DECISION DELEGATED TO DEVELOPMENT MANAGER

Application No: H22-0070-19 **Applicant:** Seagate Homes (UK) Ltd

Proposal: Details of external materials, design and position of external boxes, gas flues and soil vent pipes, boundary treatment and Management Plan for Public Open Space (Conditions 4, 5, 7 and 8 of H22-0202-16)

Location: Land Off Dean Close/Small Drove Weston Spalding

See Drawing 293.BT.03

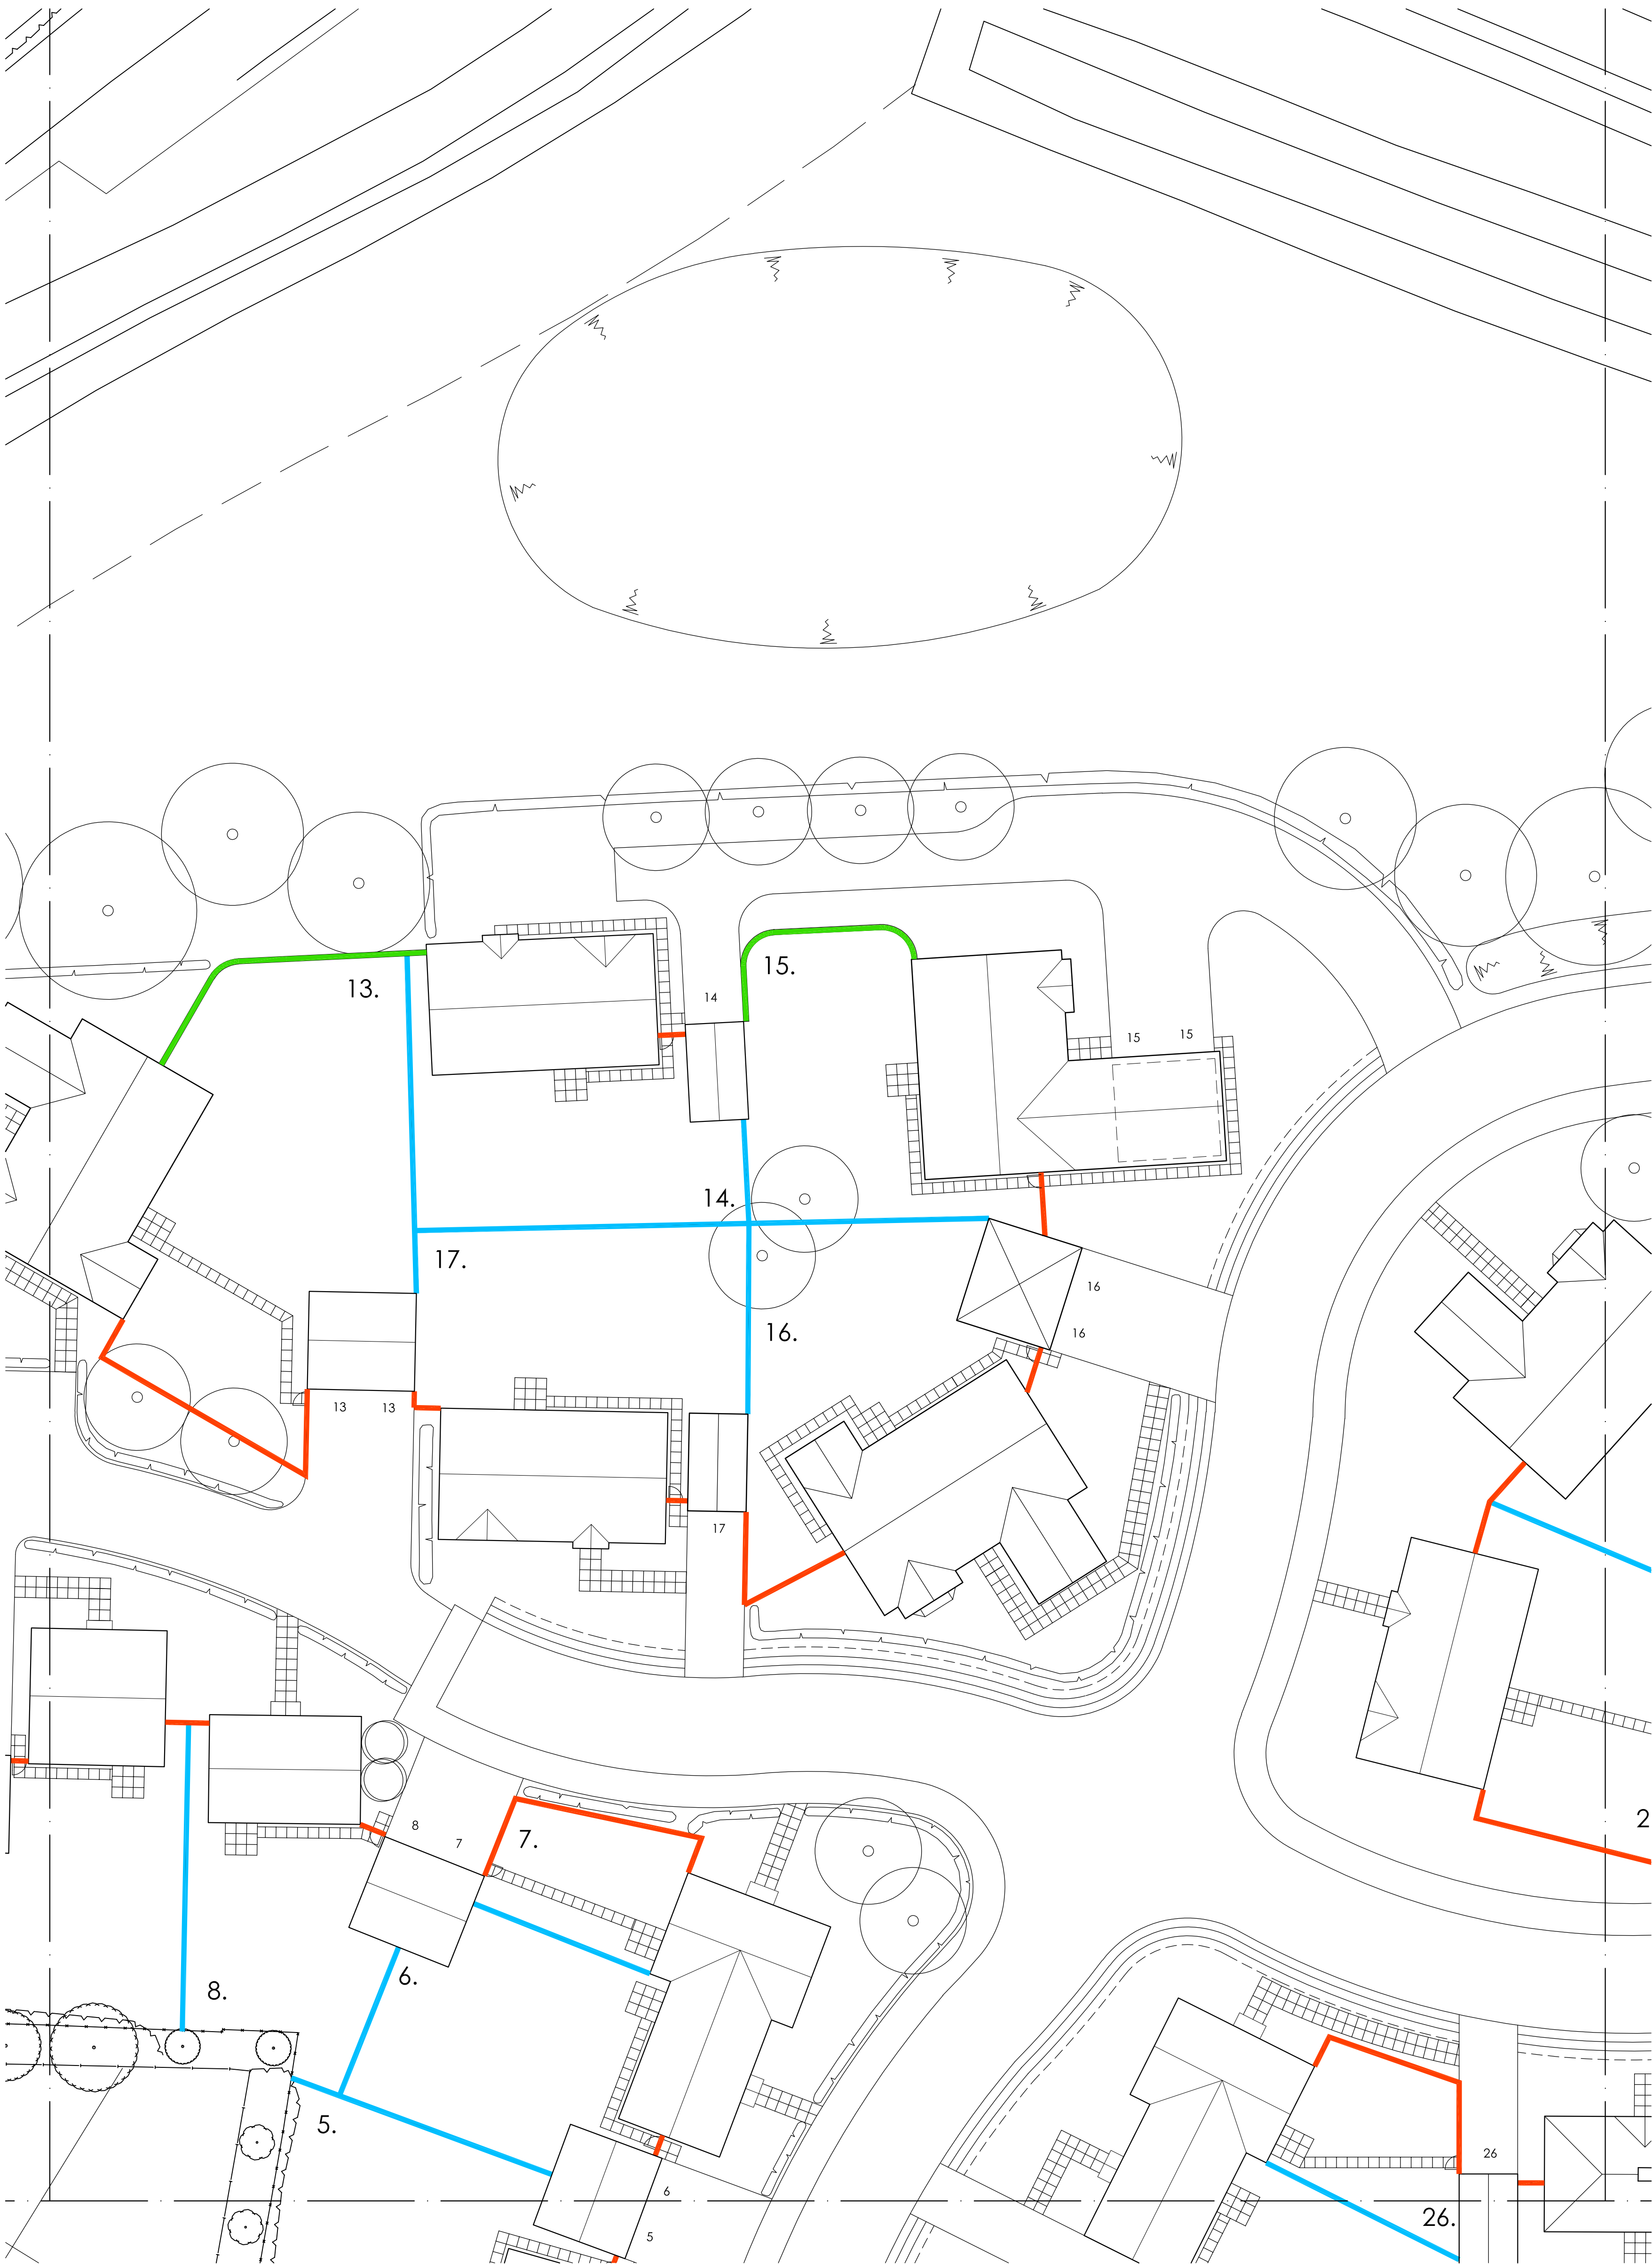
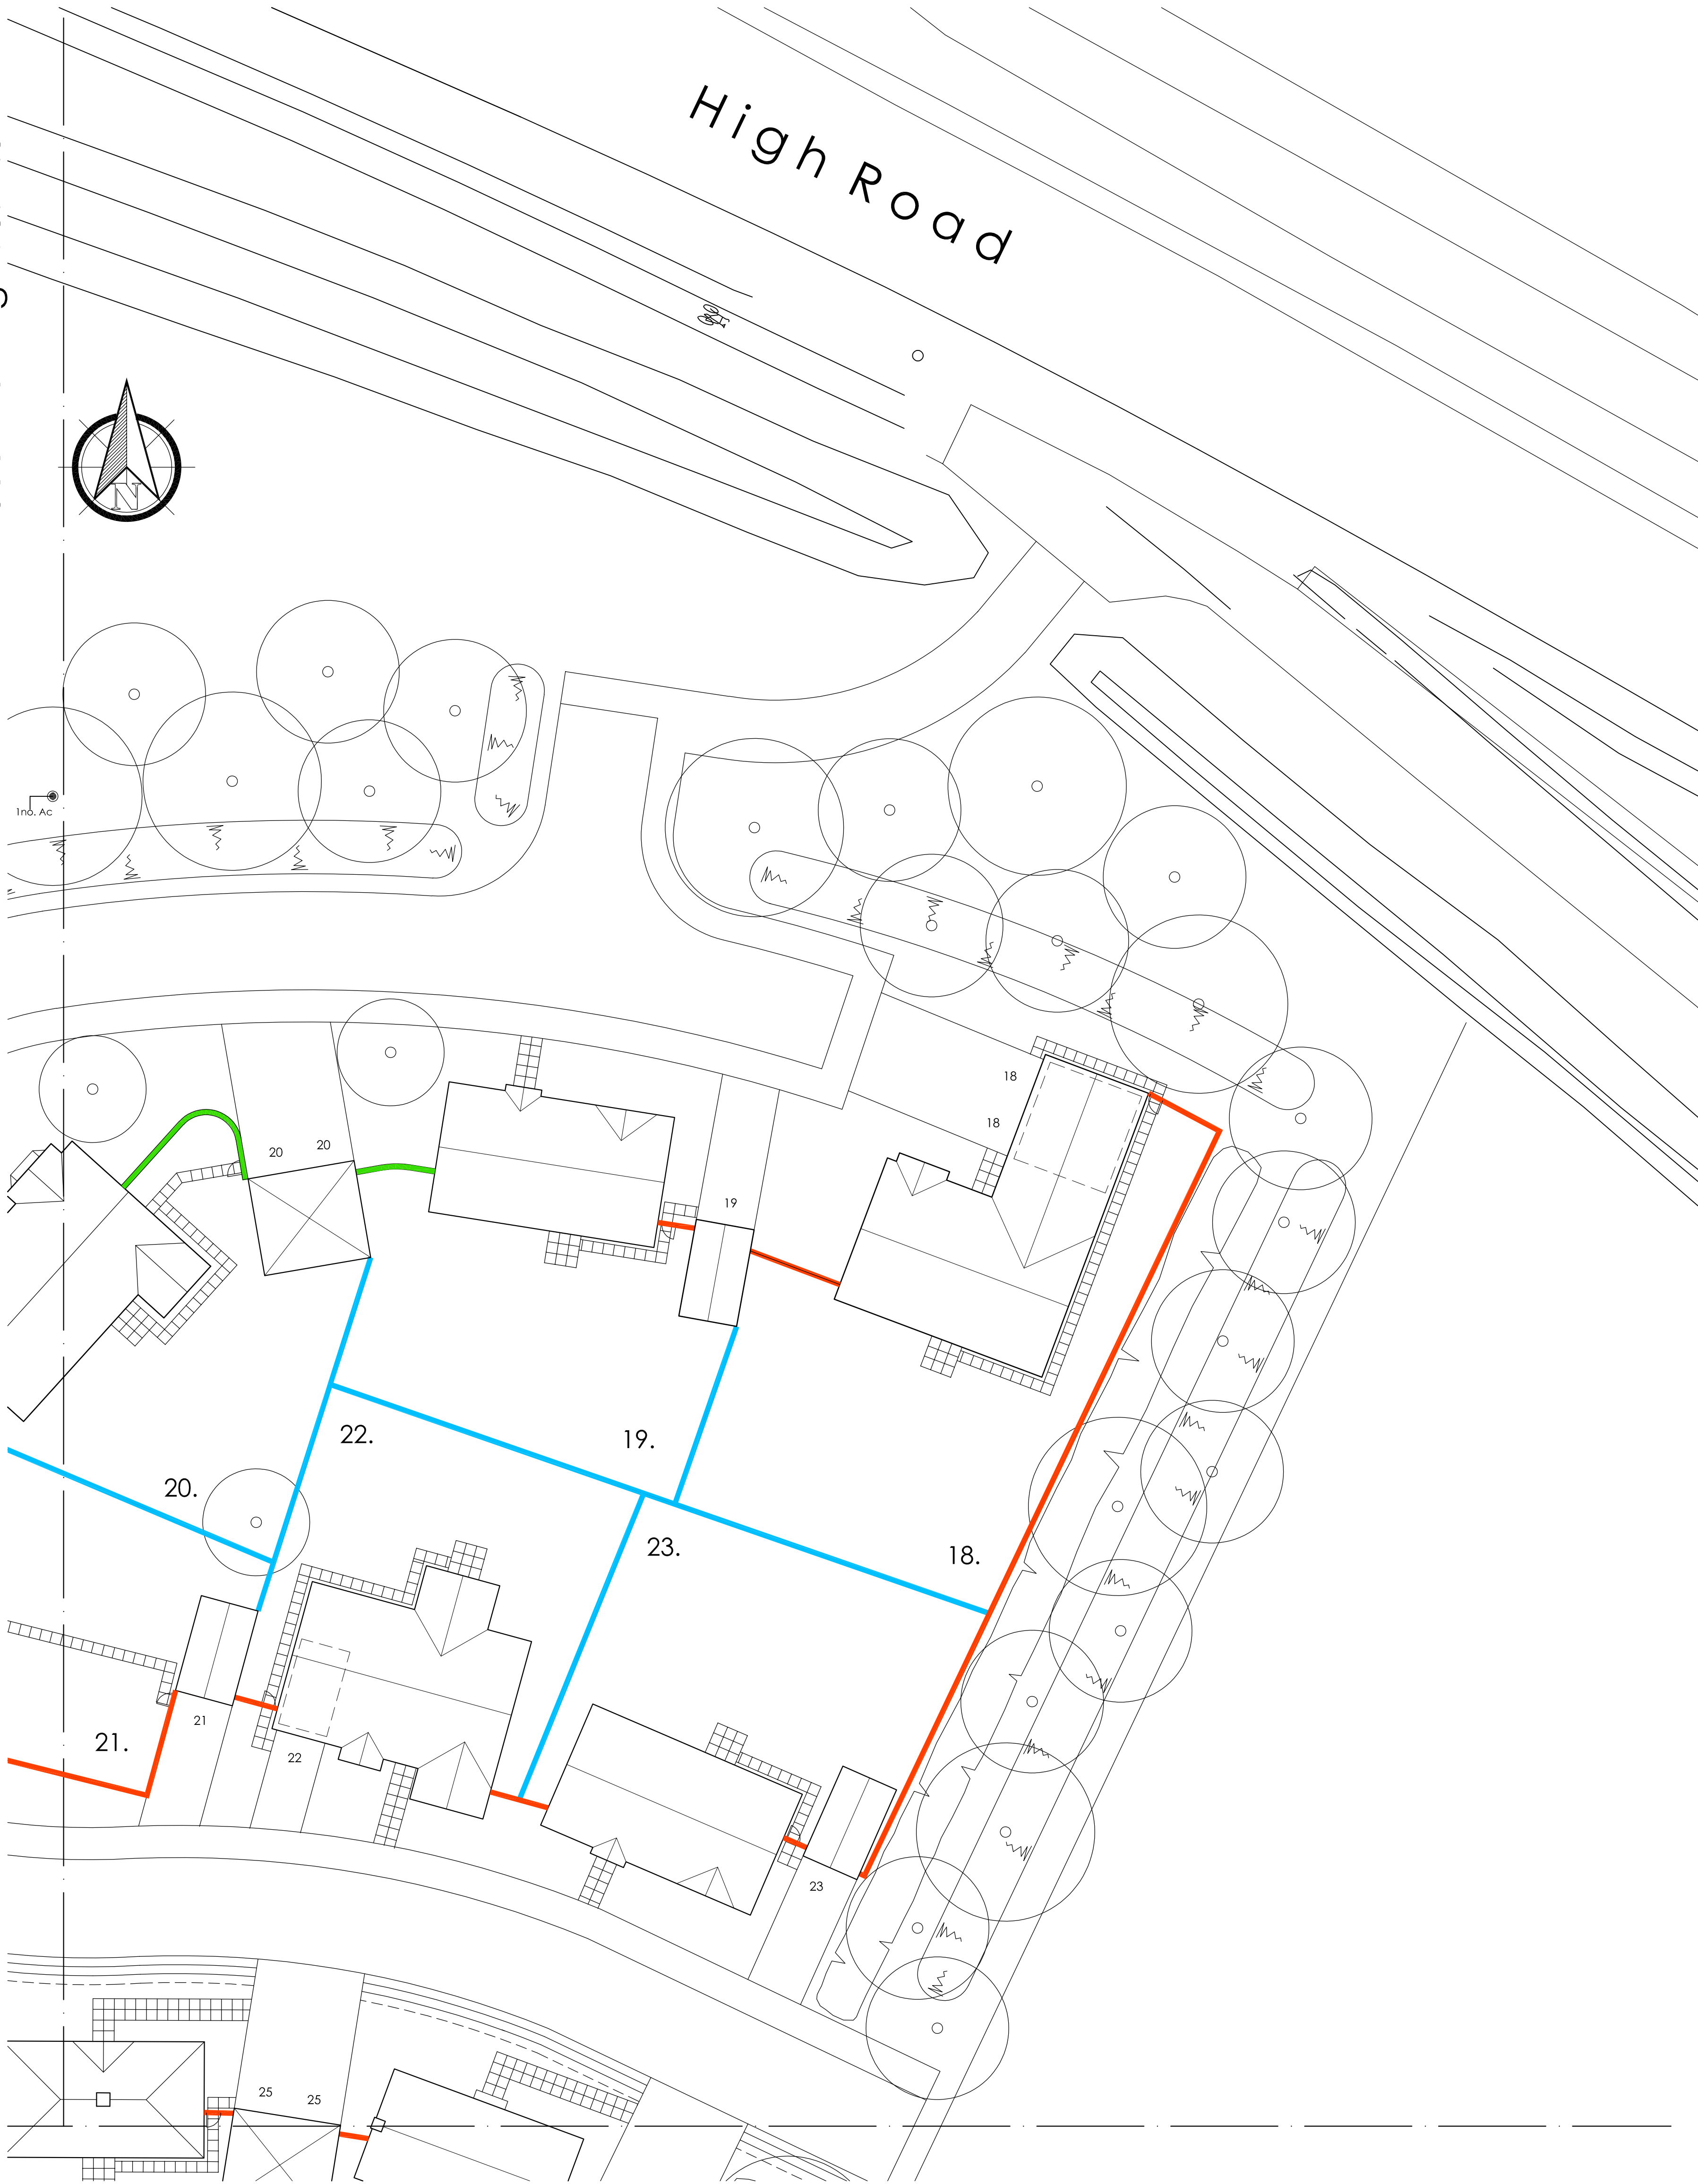
Boundary treatments are proposed to comprise predominantly of 1.8m close board fencing and 1.8m timber panel fencing.
